Jeanie Bourke - Re: Fw: 59 Washington Ave., BP#2014-00341 plan review comments

Please provide the Suite or Unit number for this area in the building. Also Provide a basic code review of the building including: **There is no unit #. The building address is 55-75 Washington Avenue and we are 55 Washington.**

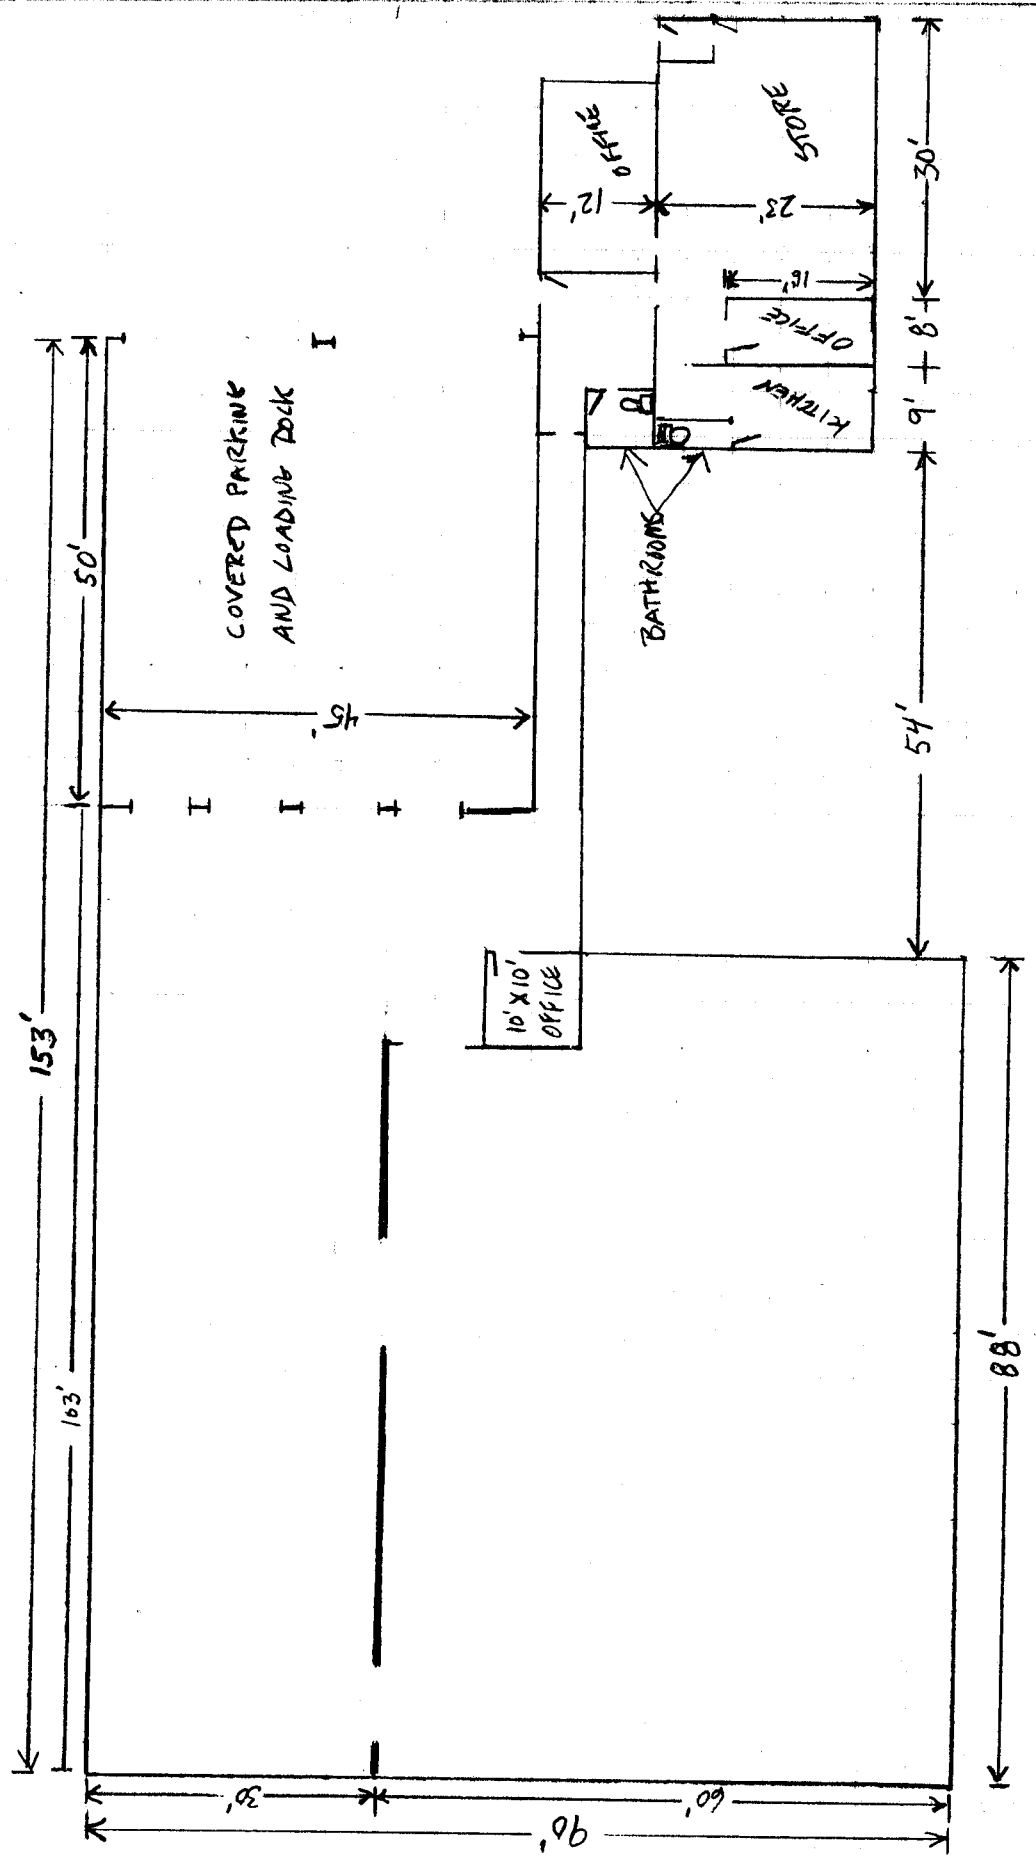
Please provide the Suite or Unit number for this area in the building. Also Provide a basic code review of the building including:

1. The type of construction for the building
2. Egress locations, travel distance, door swing
3. Designate what the use of the rear space will be
4. Is Suppression required and if provided
5. Life Safety plan with devices
6. Is there a second floor, there is a stair in the rear? Show all these details on the plans.

Masonry

See crude drawing

Shelving and storage for 200 managed commercial and residential units, wood shop area that is for repair of apartment related things such as windows, doors, kitchen cabinets, etc. Storage for appliances, hot water tanks, and other emergency items needed during off hours when vendors are closed and we need to make emergency repairs.

Full sprinkler system in place

No second floor. Rear emergency exit for all tenants on this wing.
